Engineers Comments Regarding Surface Water Drainage

Application Reference:	LU/157/26/PL	Reviewer Reference:	ADC/EXT5/AF
Planning Officer:	Hebe Smith	Date of Review:	22/09/2026
Site Name:	Wick Football Club Crabtree Park Coomes Way Littlehampton BN17 7LS		
Application Description:	Change of surface from grass to artificial turf and erection of new 2.5m acoustic fencing. This application is in CIL Zone 2 (zero rated) as all other development.		
Assessment Number:	2

Soakaway Test WS01 Cycle 1

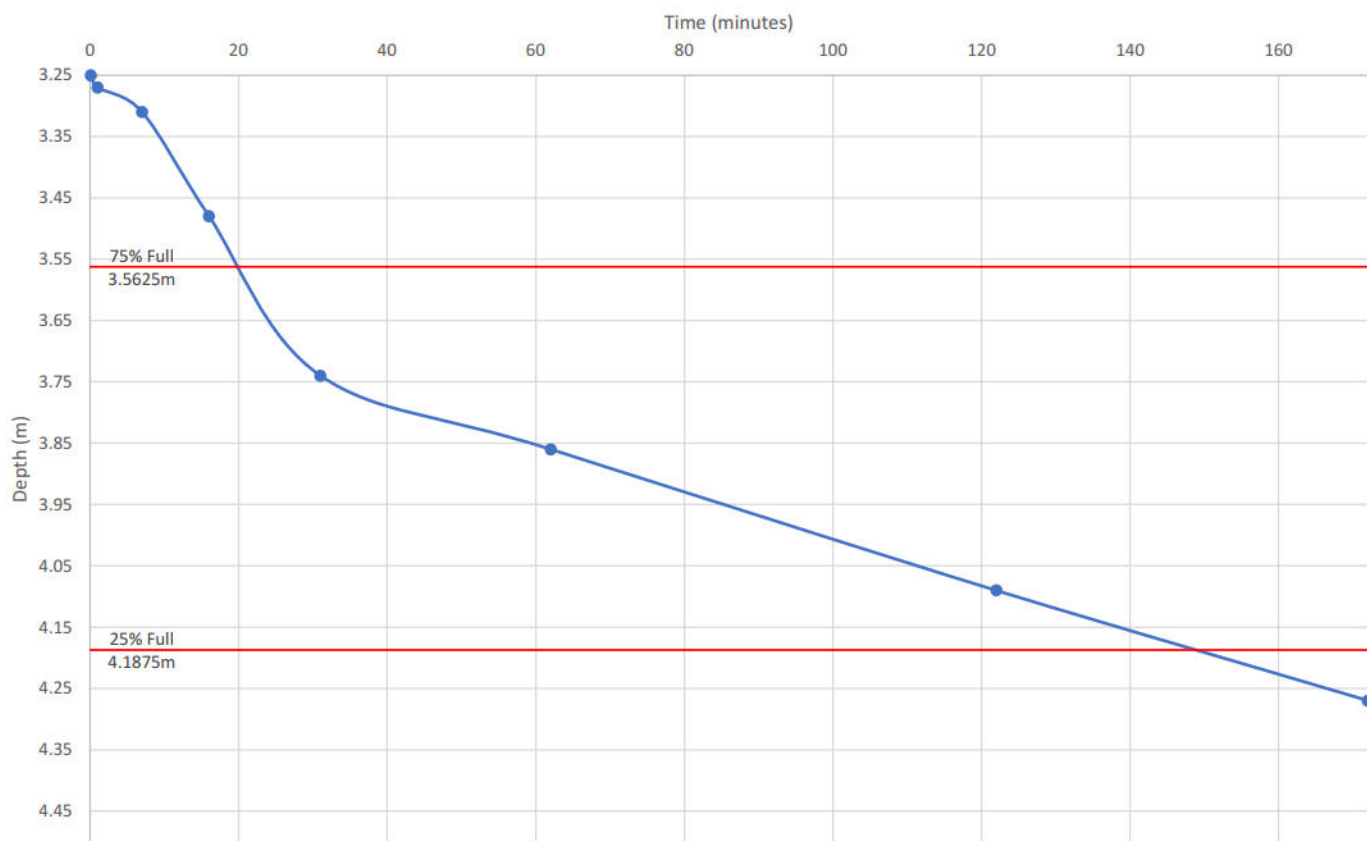
- 1.1. We understand the pitch will be 3G (rubber crumb and synthetic grass) and therefore would not require irrigation.
- 1.2. Site investigation has been carried out in April 2026 and included infiltration testing at 1 metre below ground level (Clay subsoil), which returned no viable infiltration, and at 4.5 metres below ground level (Sand subsoil), which returned viable infiltration from a single fill. No groundwater monitoring has been undertaken.

- 1.3. The single test result at 4.5 metres below ground level is not sufficient to demonstrate infiltration potential as three tests in quick succession are required. Without groundwater monitoring it is not possible to demonstrate that an infiltration feature would remain at least 1 metres above high groundwater level. It is probable that groundwater would preclude infiltration features at this depth.

Appendix G
Proposed Drainage Strategy
JPP Consulting drawing no. 31285-FRA03

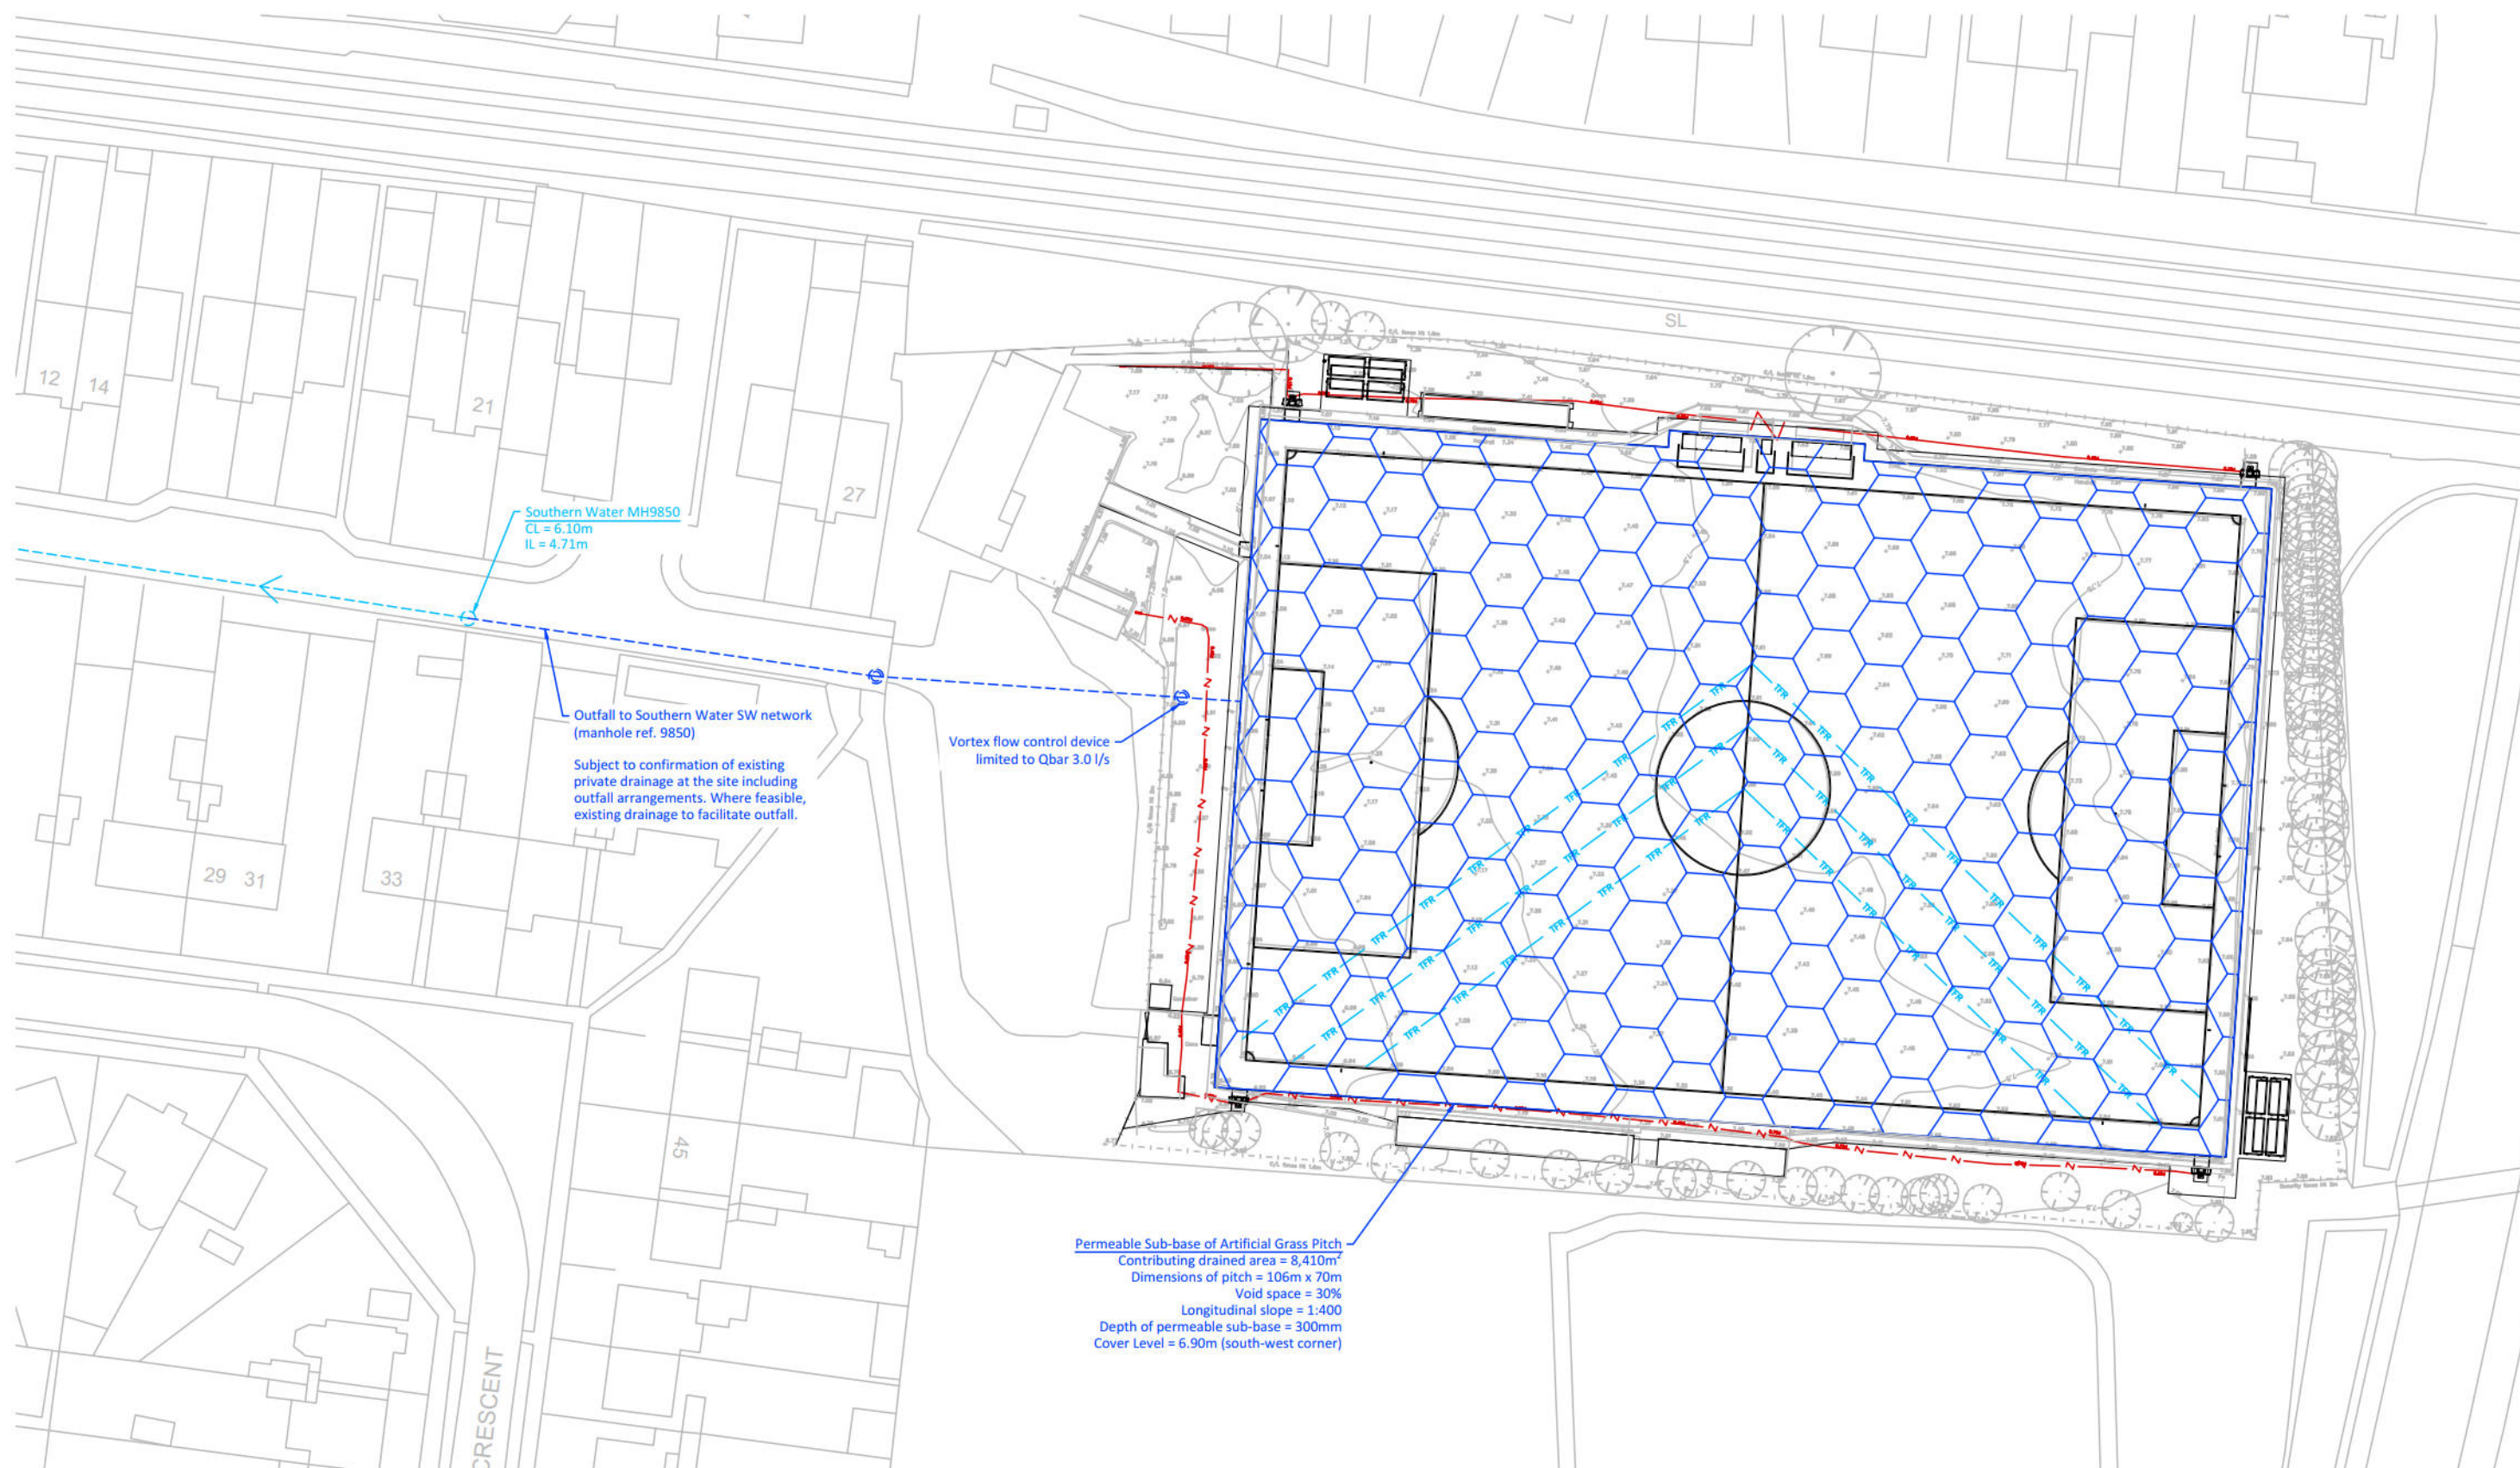
- 1.6. The proposed discharge to the surface water sewer is acceptable if further ground investigation shows that infiltration to ground is not feasible, following the drainage priorities in Standard 1. Further ground investigation could be the subject of a planning condition on the basis of there being an alternative outlet via discharge to the sewer.

- 1.7. The feasibility of connection to the sewer should be confirmed through a capacity check with the asset owner and additional levels information provided on the drainage layout to confirm connection by gravity is feasible.
- 1.8. Further information is required to confirm the design is in accordance with the requirements of the NSfS (Standard 1). The current submission does not demonstrate compliance with the standard, therefore, we **Object** to the development.

- 3.3. The drainage layout should include sufficient finished ground and below ground drainage levels information to demonstrate feasibility subject to technical design.

- 3.4. The ability of the downstream sewer to accept the flows should be confirmed through capacity check.
- 3.5. Whilst it is noted the risk is low due to the use of permeable paving, the exceedance paths should be updated to include the carpark design and to demonstrate where exceedance flows leave the site without flowing towards the existing building.

Appendix I
Proposed Drained Area
JPP Consulting drawing no. 31285-FRA02

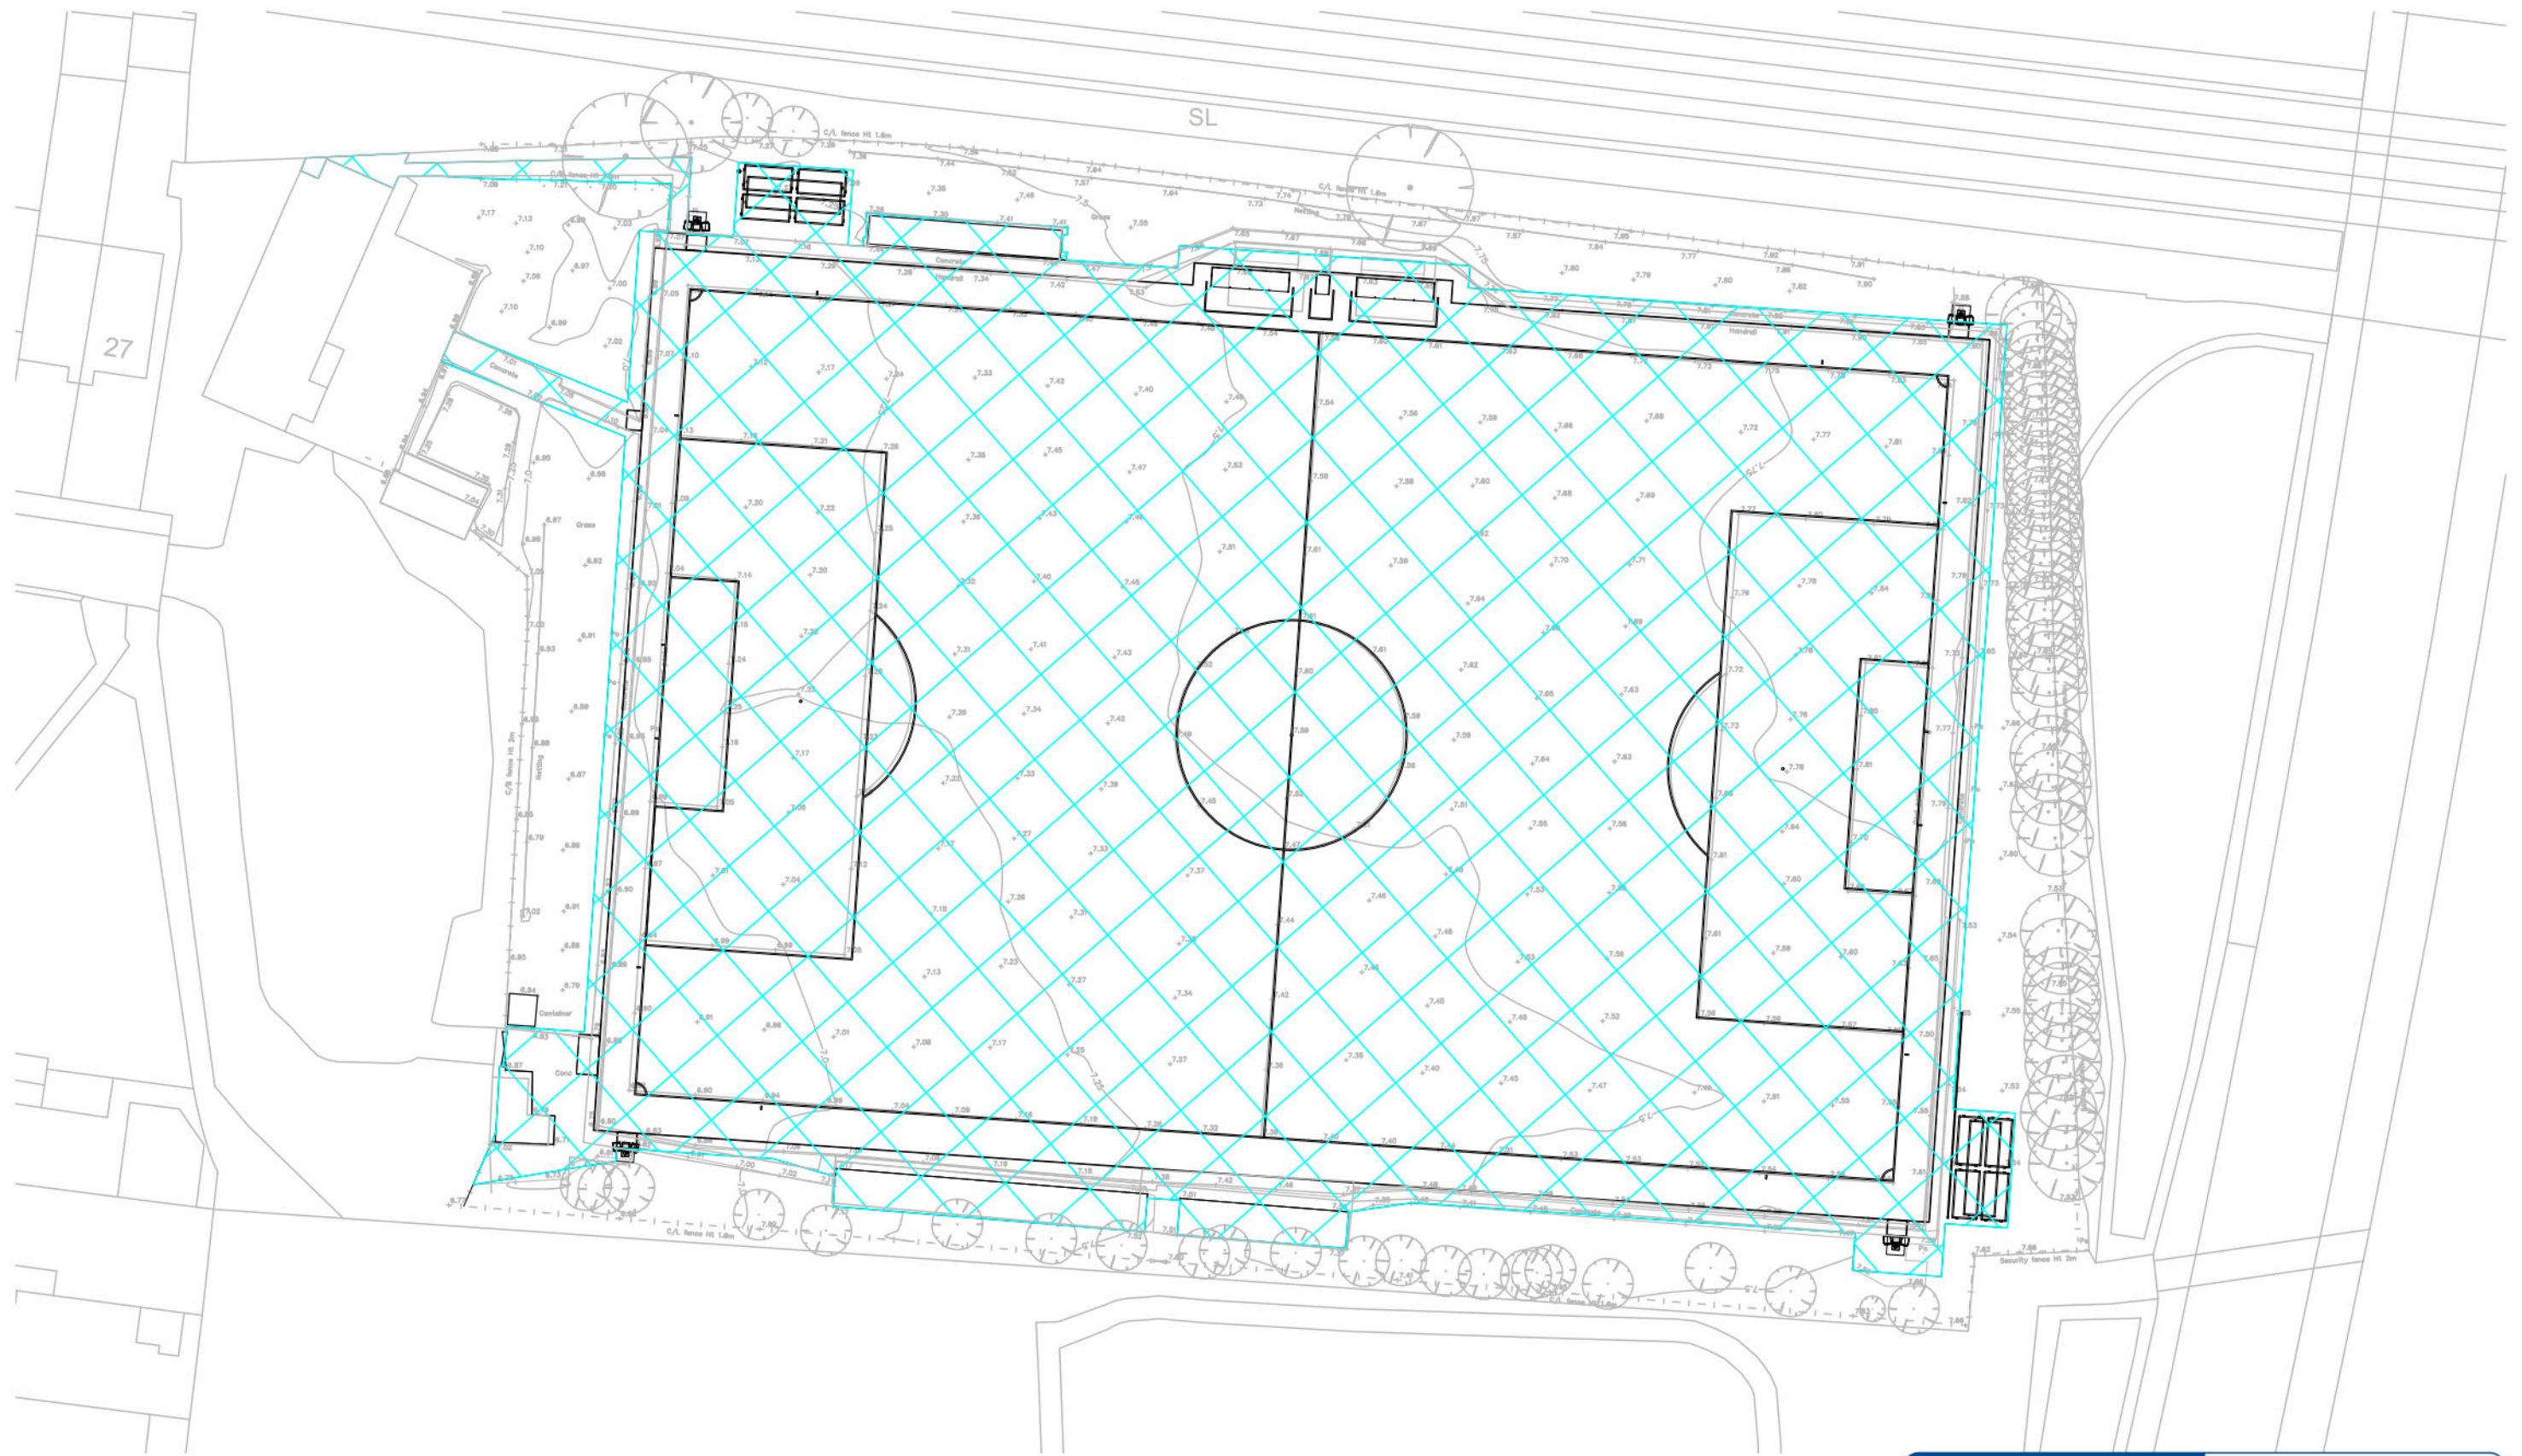
- 3.1. The greenfield runoff and drained areas should be confirmed with reference to the revised Proposed Site Plan (SN25-0487 DWG SP 0001 .00). This may affect the design peak flow rate, which can be based upon 3 litres per second per hectare of drained area (if more than the calculated value).

- 3.2. The drainage layout should include all drained areas within the site boundary. The design should therefore include the proposed carpark to the west of the pitch.
